Job ID: 2011-06-1396-ALTCOMM

has permission to Phase 1. Change the Use from a community hall to karate center, basement & 1<sup>st</sup> flr, 2<sup>nd</sup> floor vacant provided that the person or persons, firm or corporation accepting this permit shall comply with all of the provisions of the Statues of Maine and of the Ordinances of the City of Portland regulating the construction, maintenance and use of the buildings and structures, and of the application on file in the department.

# Fire Comments

# 1854 FOREST RE-MODEL

1844 FOREST
1844 FOREST AVENUE, PORTLAND, ME 04103
BASEMENT & FIRST FLOOR PLANS

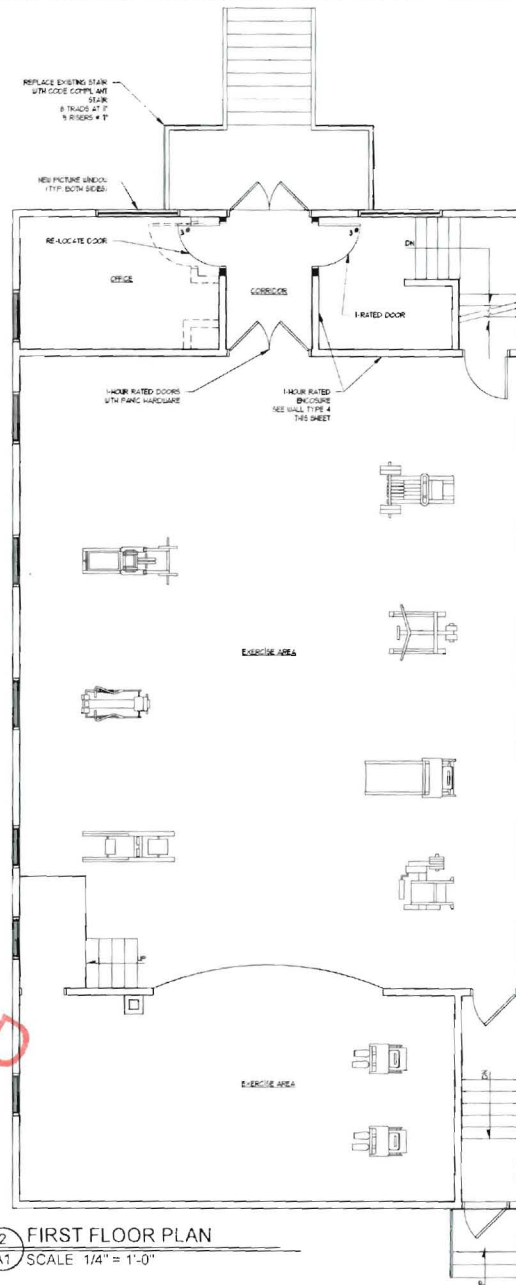
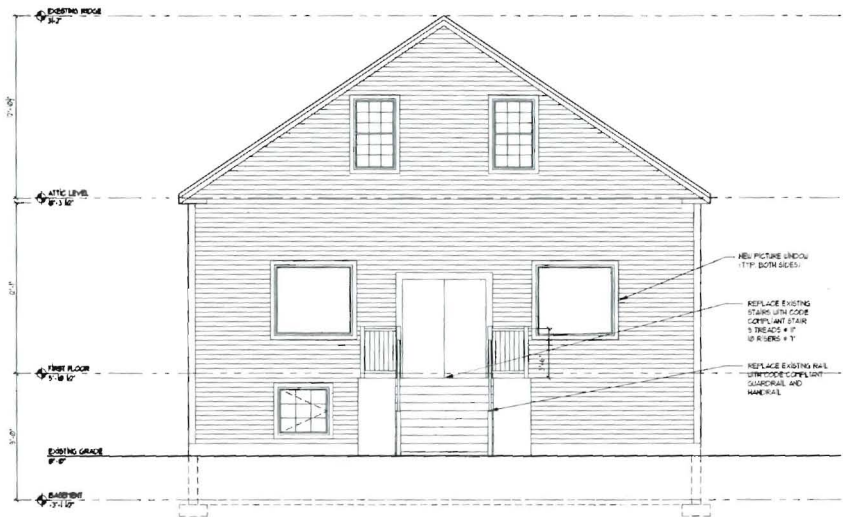
*Floor Drains in BM's*

*Water fountain*

1 BASEMENT LIFE SAFETY PLAN
LS1 SCALE 1/4" = 1'-0"

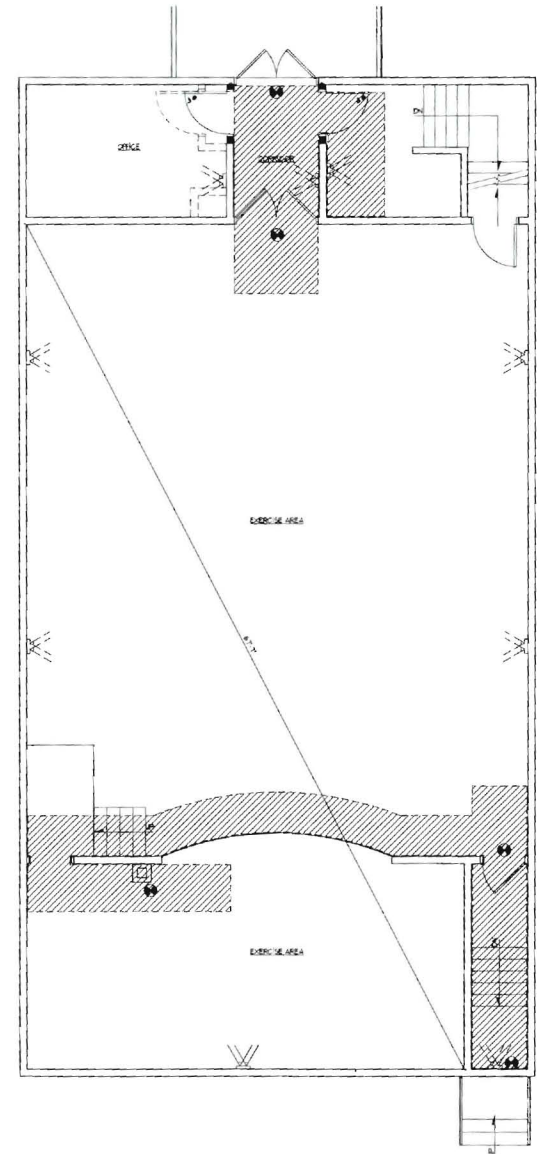
The stair between the basement and first floor has dueling doors between the basement and bathroom doors. It's not a required exit from the basement, but it is from the first floor.

The rear exit from the basement does not need to be enclosed. It does not penetrate floors, but only climbs a few steps and exits directly outside at grade.
